**RE: SSD 7462 – Minto Recycling Pty Ltd (Bingo Industries)  
No. 13 Pembury Road, Minto**

I refer to the Department's correspondence regarding the proposal to increase the permitted tonnage of waste per annum permitted to be handled at the subject site from its current 30,000 tonnes.

This response has been prepared following receipt of amended information from the proponent, which was prepared in response to submissions raised during the application's public exhibition.

Swept Path Analysis and Vehicle Stacking Plan

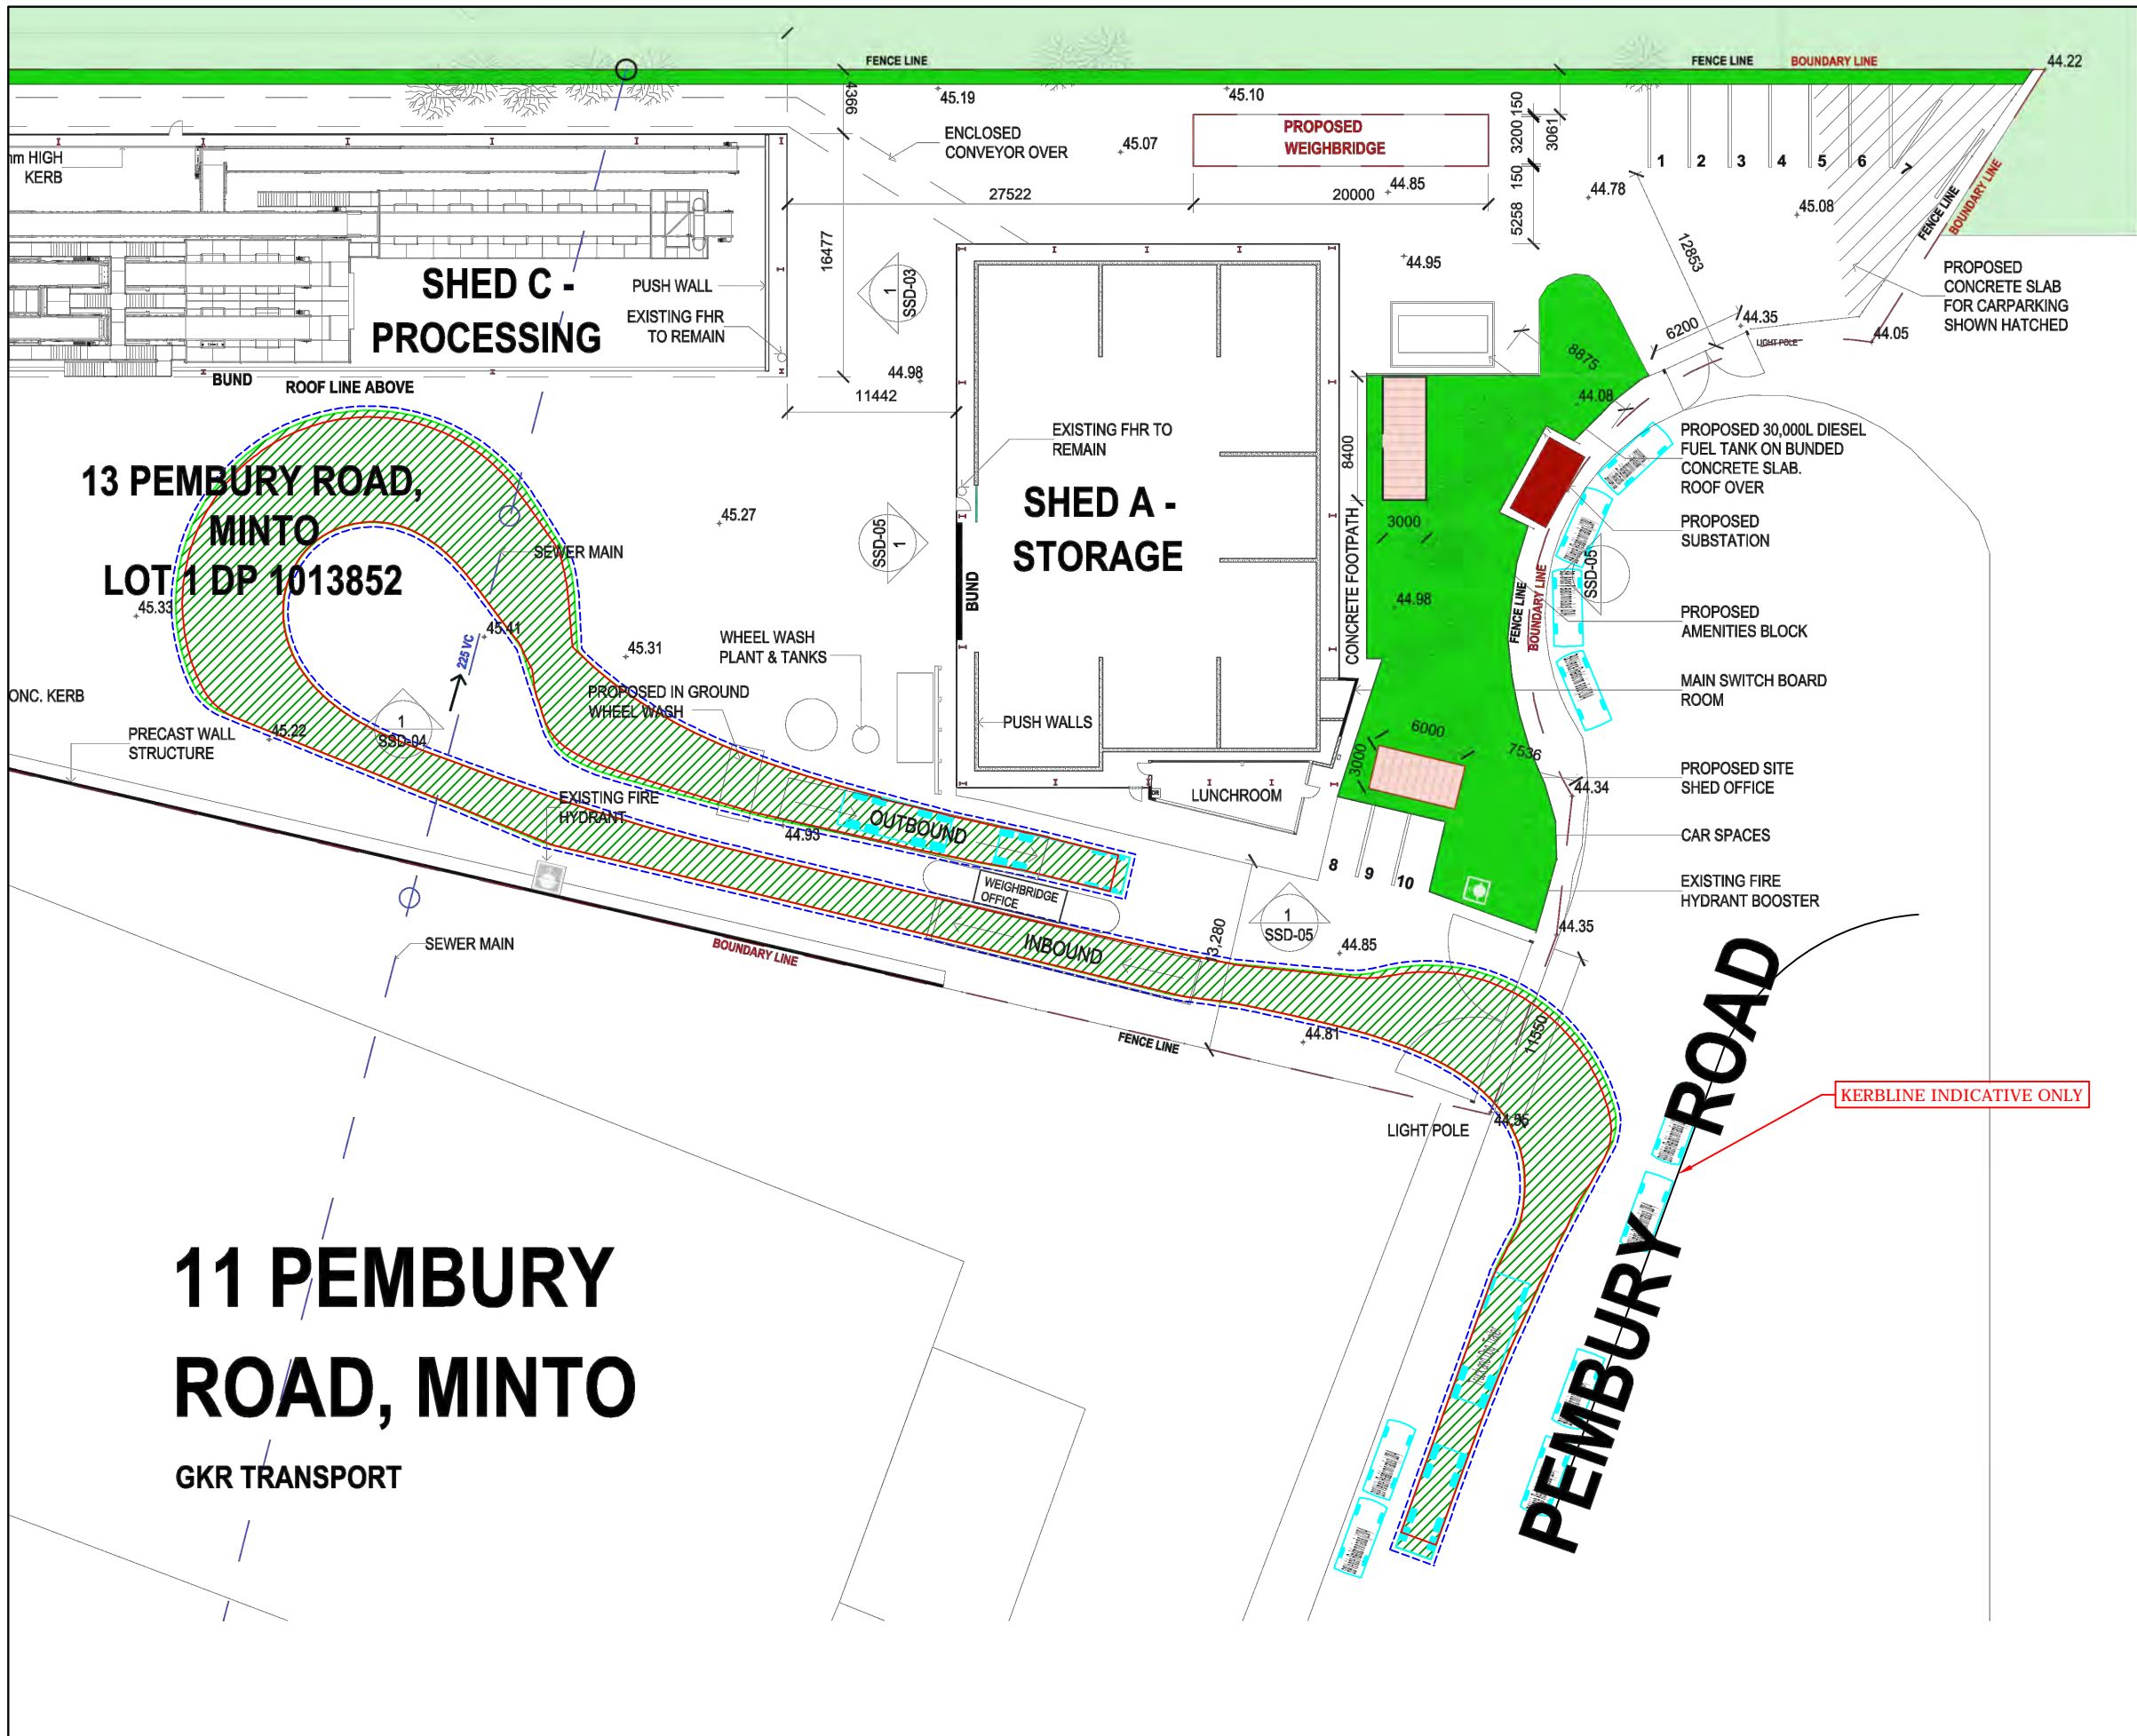
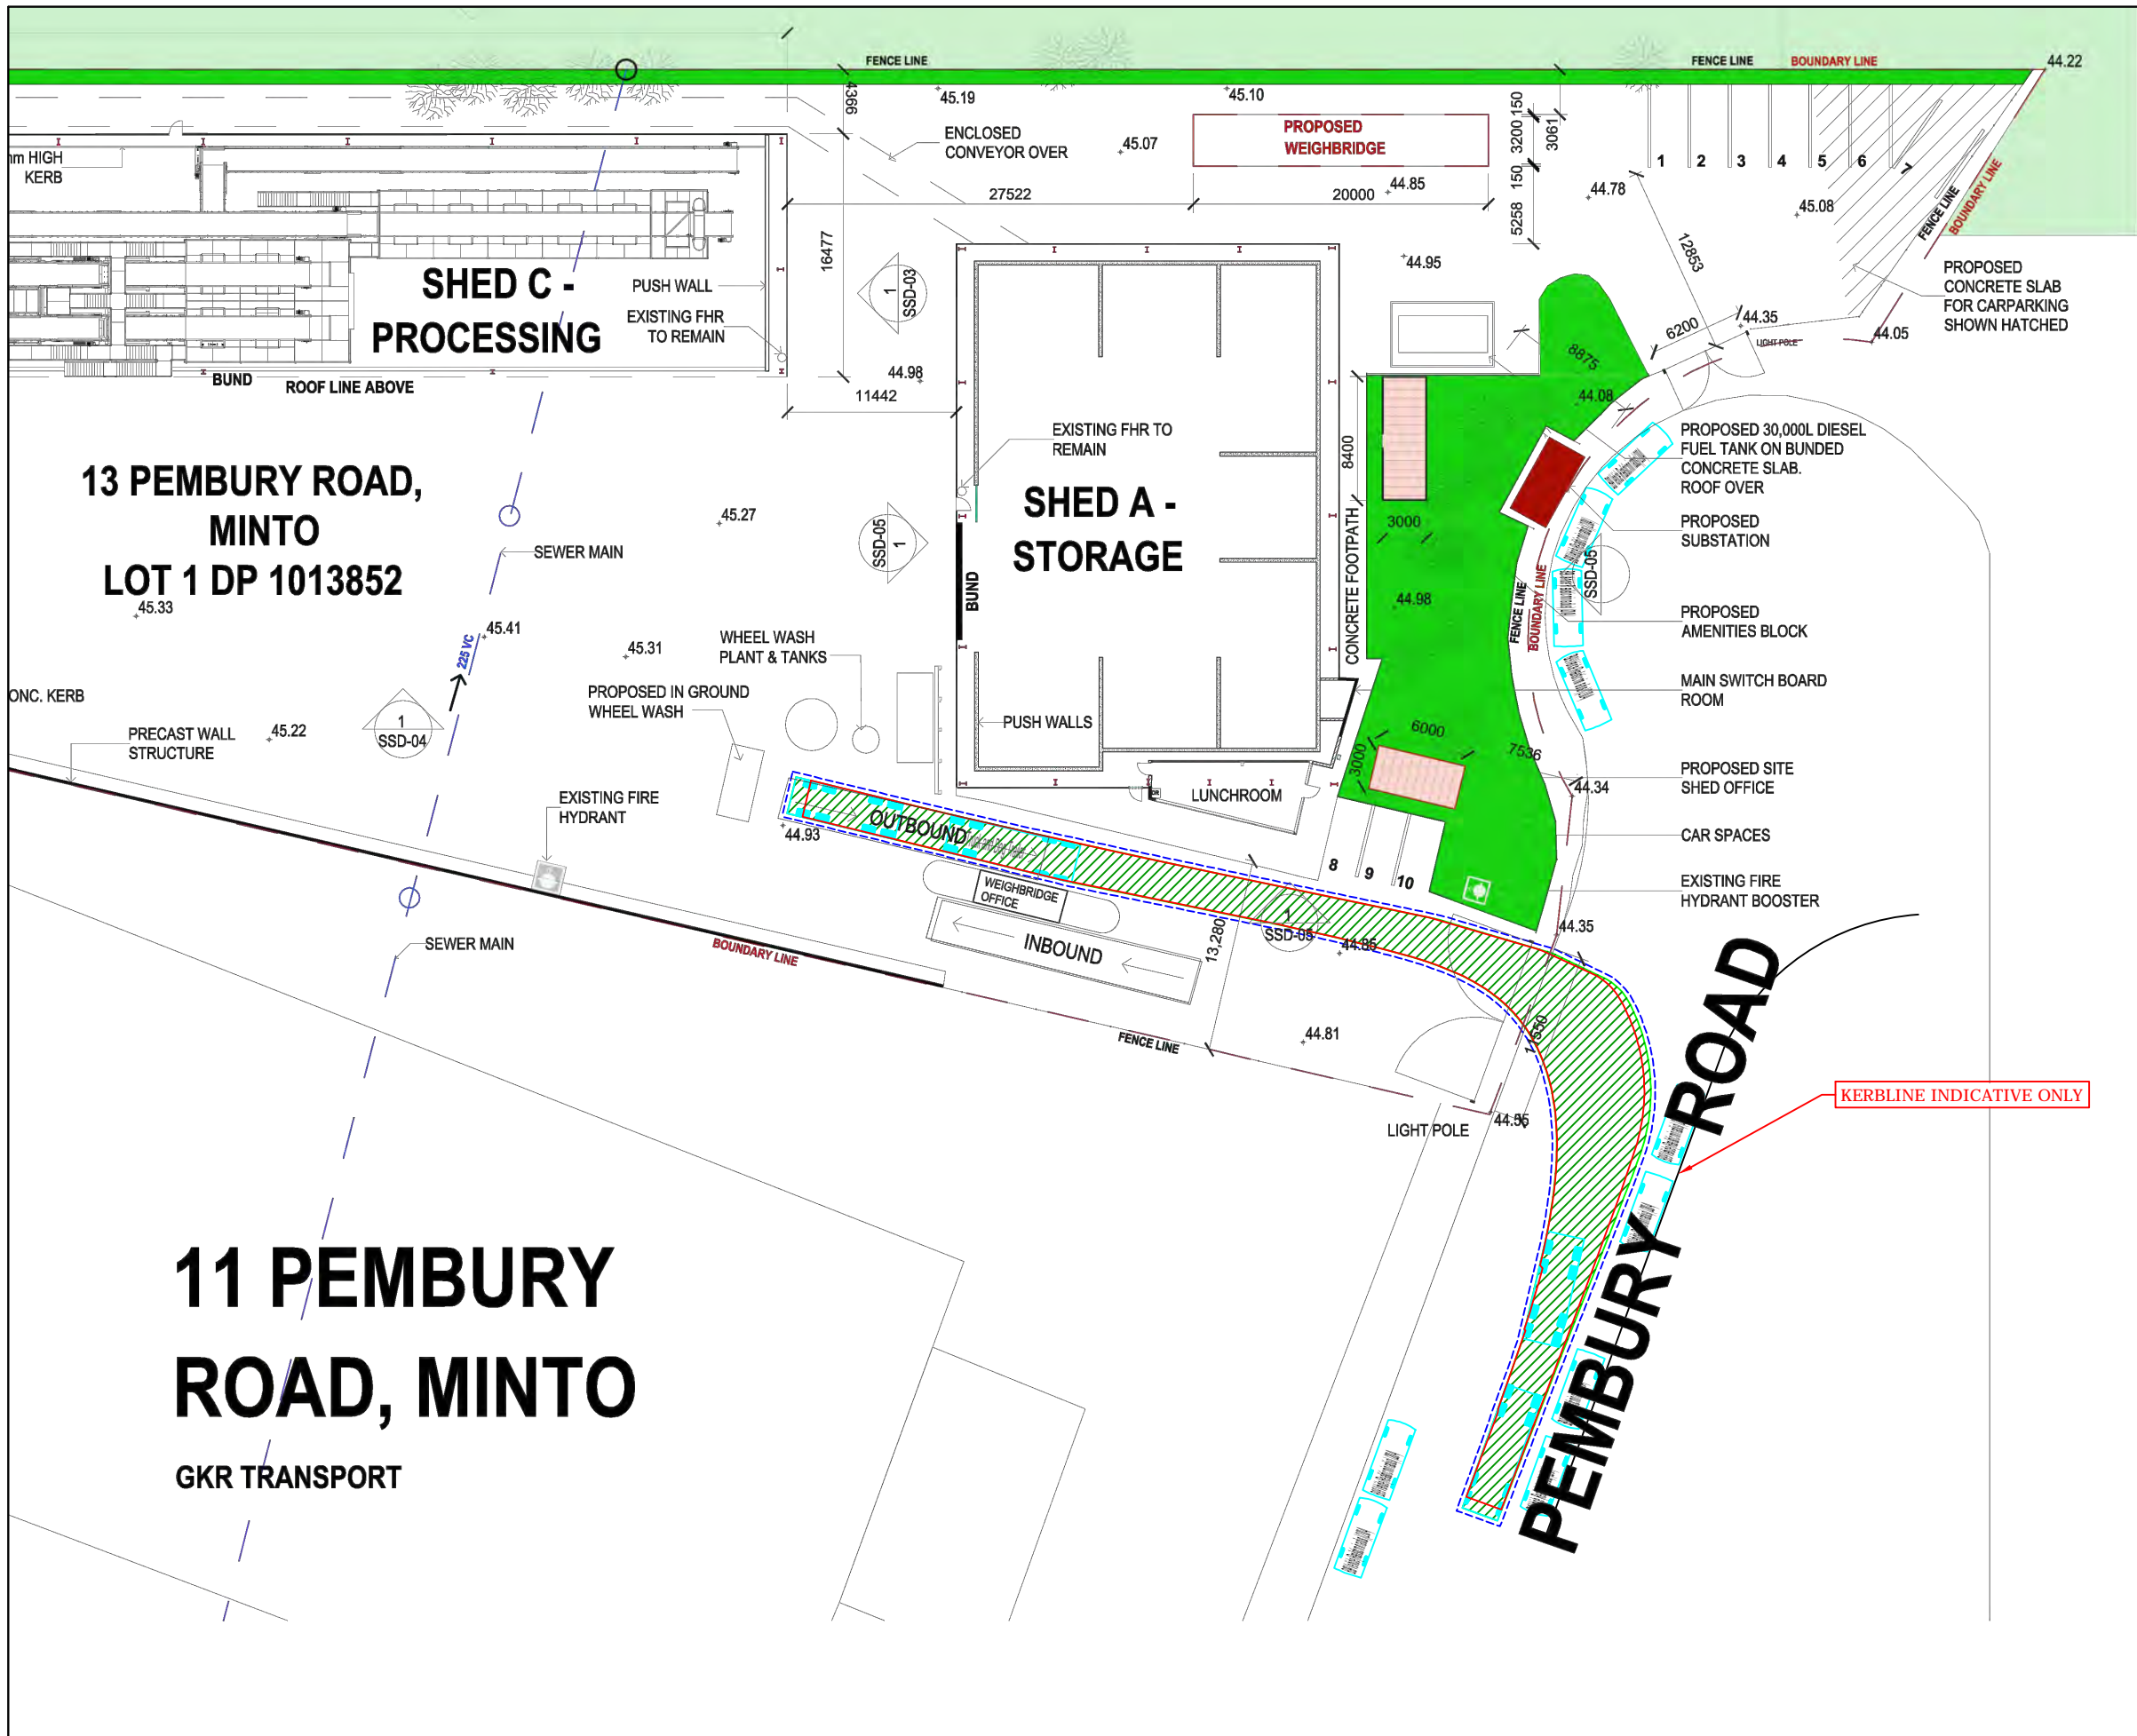
- The turning manoeuvres shown on submitted plans do not appear to be practical in some instances – with wheels crossing over weighbridge edges and the like, which is likely to damage the weighbridge and not be a permitted practice on site. The weighbridges are not generally flush with the surrounding pavement surface. Rather, they are likely to have a raised kerb or other raised element to ensure the vehicle is located appropriately.

- The stacking proposed within the building is not considered to be appropriate in terms of manoeuvring for articulated vehicles – there is no turning path shown that illustrates how an articulated vehicle would access the stack nearest the wall should the vehicle use entry weighbridge number 2. Manoeuvring within the building as proposed is reliant on articulated vehicles being in that particular stack.

- According to submitted turning paths, not all wheels of some articulated vehicles are located on the weighbridge after entering the site. Again, this is important as the weighbridges are not flush with the pavement surface. If vehicles cannot access the weighbridge in either a timely manner and importantly, an accurate manner, this raises issues with the monitoring of the site's performance in terms of its EPA licence restrictions and also the timeliness of the queuing/unloading criteria relied upon in the traffic assessment.

- No reverse to tip manoeuvre turning path is provided for b-double vehicles within the building. Are b-doubles broken down on site in order to perform their tipping manoeuvre? If not, how is the a-trailer emptied? Breaking down of the combinations would add time and influence queuing.
